From: Amanda Scholes on behalf of Planning.Responses
Sent: 06 April 2017 10:49
To: Planning Scanning
Subject: FW: Planning Consultation on: LU/A/44/17/OUT - Land west of Brook Lane and South of A259 Angmering BN16 3JL - COMMENTS FROM LITTLEHAMPTON TOWN COUNCIL

146.2 Planning Application LU/A/44/17/OUT – Land West of Brook Lane and South of A259 Angmering on the A259

Description of Outline application (with all matters reserved) for demolition of

MASTER PLAN

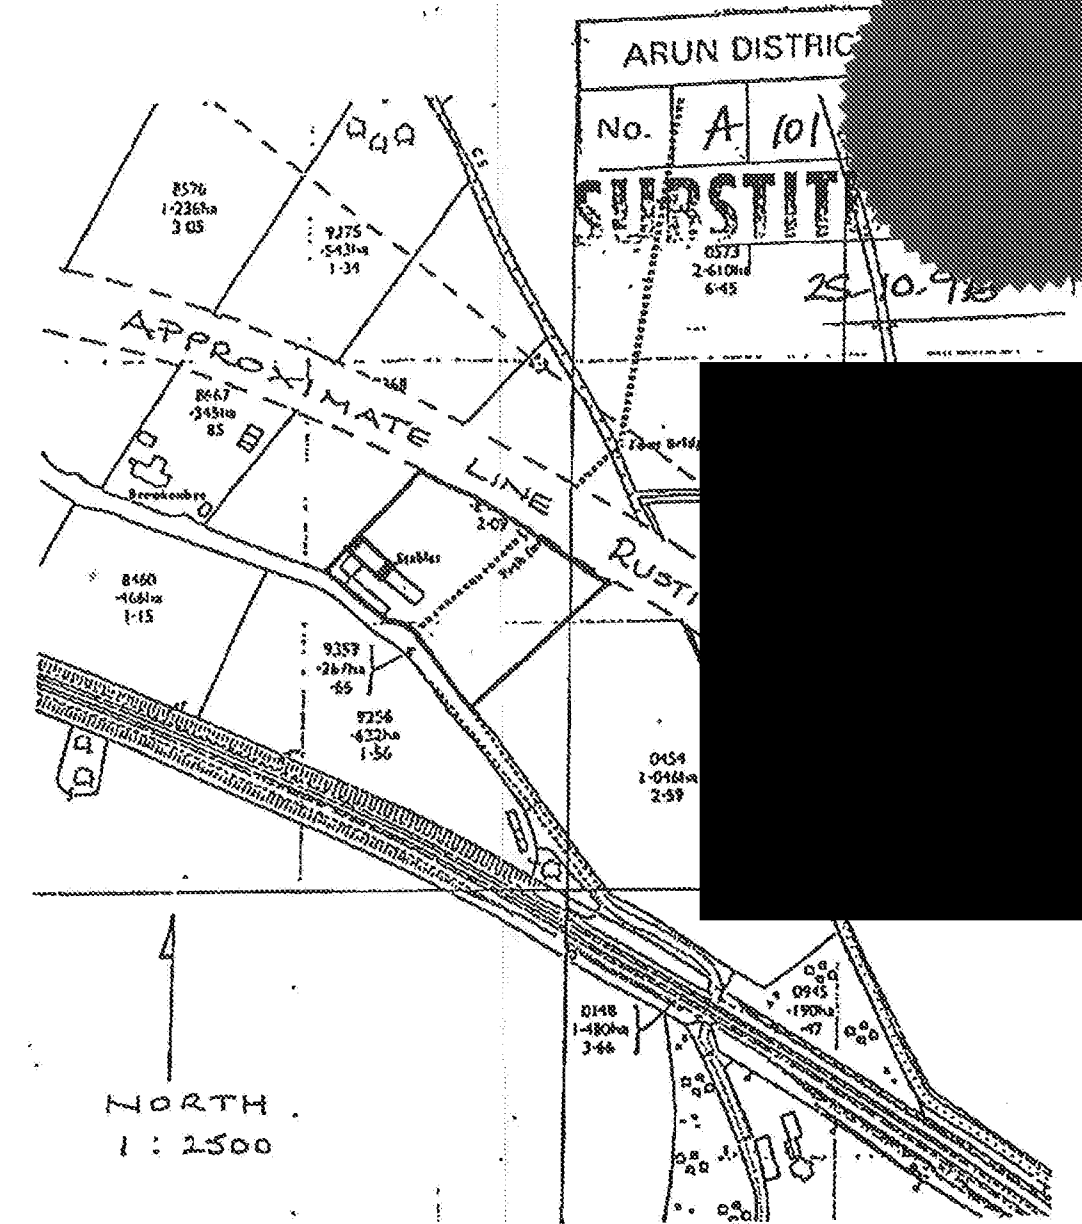
146.2.1The Committee had before it details of the above planning application which contained proposals for a mixed-use development comprised of 90 residential units and a care home and ancillary infrastructure. The Committee proceeded to review the plans in more detail. Since a dementia care home was proposed, sandwiched between a dual carriageway and a railway line, Members had serious reservations as to whether this was an appropriate location for such a facility. It was therefore judged that careful consideration needed to be given to the location of this facility on this site. It was also considered that the residential amenity of the occupiers of the housing required further thought, particularly in relation to the impact of noise from the A259. It was observed that the acoustics report failed to acknowledge the impact of noise from the A259 on the upper floors which it was thought would be difficult to contain within recommended limits. It was therefore considered that the housing design should incorporate measures to mitigate this. For example, consideration could be given to maximising the use of renewable energy to mitigate additional energy requirements of installing air conditioning. The report also called into question the impact of the noise and pollution in gardens and whether the acoustic barrier was sufficient to mitigate the effect appropriately.

146.2.2Members also expressed serious concerns about the proposed access to and from the development. With housing allocations in the local plan at Angmering, West Bank, Climping and Ford, as well as housing already being built out in North Littlehampton, the A259 was already under considerable pressure. Taking into consideration the impact on the A259 of the junction servicing the new retail park also on this stretch of dual carriageway, it was thought that the A259 would effectively become a single lane road for through traffic due to cars decelerating and accelerating into the new junctions. It was therefore considered imperative that the lanes into these junctions were long enough for this to happen safely and without causing additional congestion. It was also observed that vehicles accessing the site from the West would be forced to turn around at the Windmill roundabout on the A259 to access the new stores and residential development if permitted. This roundabout also served a busy access road from Rustington crossing the Windmill Bridge, and provided access to and from the golf centre, fitness centre and out of bounds leisure complex (with additional permissions granted for a Hotel, restaurant and further leisure uses). It was difficult to see how this combination would not have a severe impact on the highway network.

146.2.3The proposed rail bridge is considered vital to any development on the site, or adjacent to it and it was judged important that the bridge was as accessible as possible. It was observed that a new footpath/cycleway was proposed from the western end of Brookfield Park into the site rather than along the side of the A259 connecting with the Body Shop roundabout. This raised serious concerns about safety and security in the hours of darkness. Observing that the site appeared to have established Gypsy Traveller status, there was no mention of this or how alternative provision would be accommodated if the site was developed. It was also noted that when viewed from the railway parts of the site often appeared flooded. Members therefore considered it imperative to design the site to accommodate this water, as well as preserve and enhance the diverse ecology demonstrated in the conservationists' report. It is also crucial that a scheme was designed and agreed with Southern Water to deal with waste water in advance of the development commencing. Whilst Members were not objecting to the principle of the site being suitable for development, it was considered that there were considerable hurdles to overcome before they could be supportive of the plans. It was therefore **RESOLVED** that:
